MOD 2- Landscape responses

PROJECT Hammondcare Greenwich
PROJECT NO 19-165s
DATE 15.06.2026

The following are the Landscape Consultants responses to the RFI's raised by DPHI / Council's review of the Modification 2 submission with regards to additional information and clarification.

PODIUM LEVEL BELOW

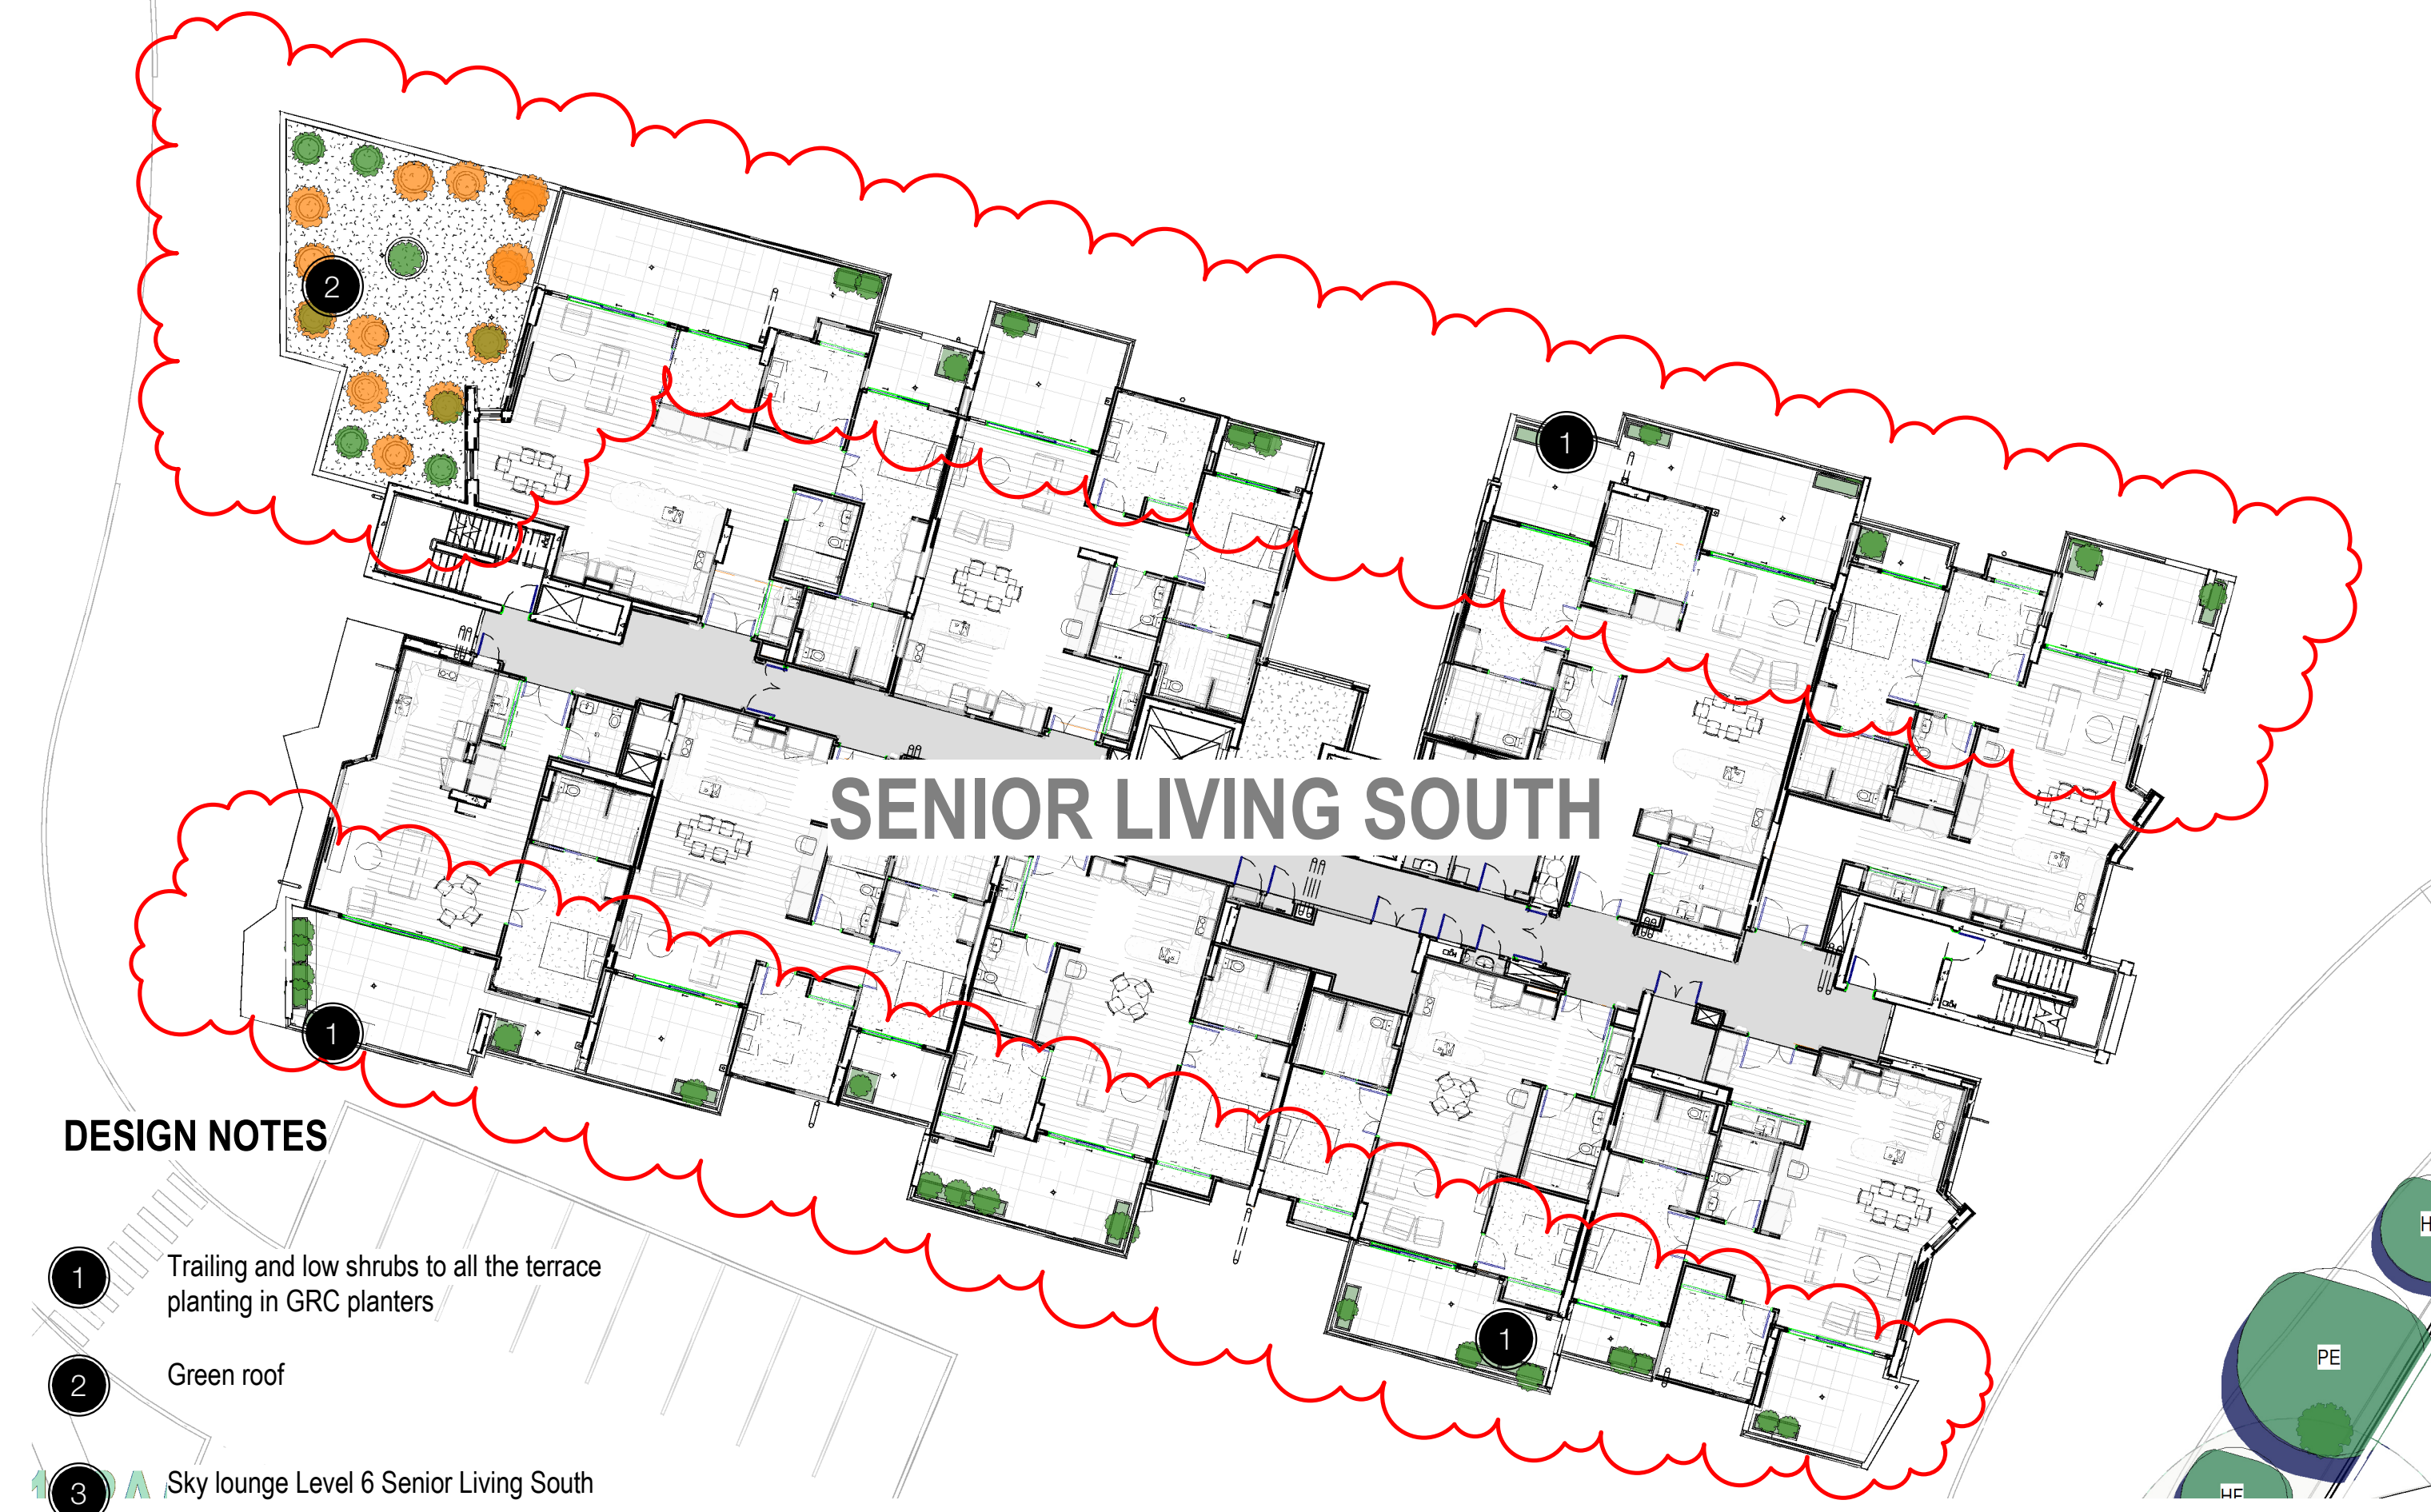
- b) The planters on the apartment terraces of the Seniors Living building's, have been substituted with GRC planter boxes. This change responds to issues identified during the Detail Design phase and takes into consideration buildability input, water proofing detailing and the construction program. Items resolved include waterproofing, drainage and appropriate separation between planter media and the slab. GRC planter sizes were selected based on size and market availability, with minor changes to the soil volume. (Refer to LA-SL-203 [E], LA-SL-204 [E]) We note that the south-western planter at the Seniors Living North building, closest to the adjoining residential properties, will remain as a raised planter that supports screening vegetation as is required by the SSDA. (Refer to LA-SL-203 [F], LA-SL-204 [F])

Planters that were isolated and maintenance access is difficult, have been removed. Privacy and screening issues between the Seniors living north and Seniors living south are unaffected as the distance between the terraces exceeds 15metres.

REVISION: P29
DATE: 30/09/2025
DRAWING TITLE: DD-SW-0202
SITE LEVEL PLAN - LEVEL 3 (MEZZANINE)

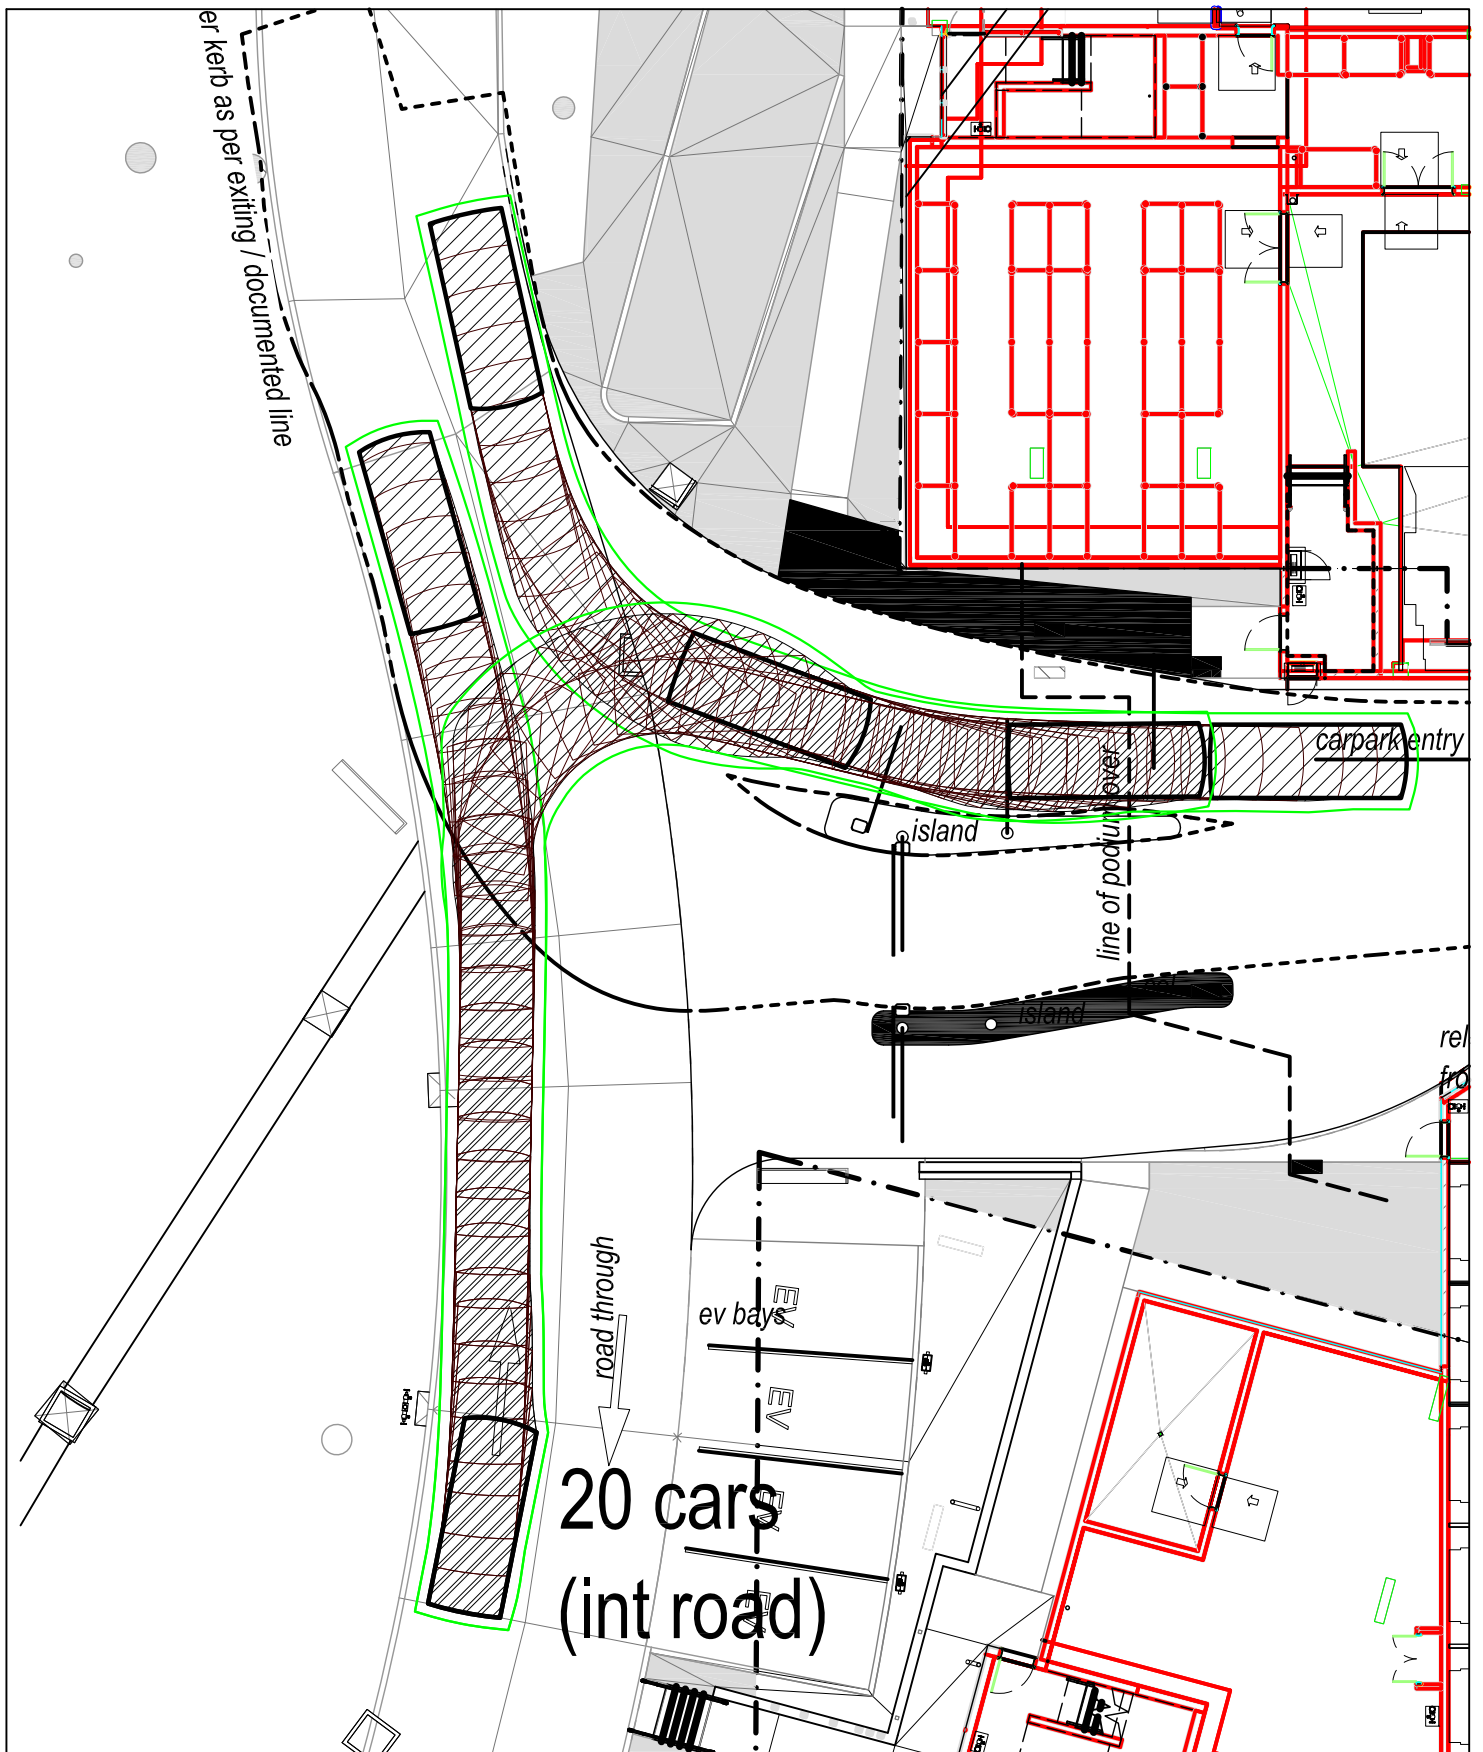
RFI-10	<i>Appendix G Landscape Response notes that hospital building planters at level 2 drop off area will be amended and replaced with GRC planter boxes, and that only the planters along the building façade have been removed due to waterproofing and</i>	Refer to item 1.1 NB THIS REFERENCE IS TO A BM DRAWING OF THE SAME AREA THAT HAD OMITTED THE LANDSCAPE PLANTERS.
--------	--	--

structural considerations. This needs to be reflected on the DD-SW-0201 and any other relevant drawing, as currently it just notes 'planters removed'. Please revise with the new GRC planter box locations..	
RFI-11	The modification report notes that there are changes to some plant species, and there is a reduction in some landscaping across the site. Please provide a revised plant schedule to reflect the landscaping changes proposed.	The changes to Senior Living Roof planting has been capture in this MOD 2 2.0 The flammability of the roof garden areas on Seniors Living South was reviewed and the as it falls within the line of the APZ. John Travers advised that planted area needed to comply with Appendix 4 of PBP 2019. The green roof areas were reduced away from the vents and exhaust pipes etc. And the maximum height of "Low volatility plants is to be less than 60-90mm in mature height", directed the change in plant species composition to a "Sempergreen sedum carpet " as it is pre-grown full soil coverage with plant material removing the need for mulch. Spot planting of native and endemic species that fit the specification to diversify the planting mix.
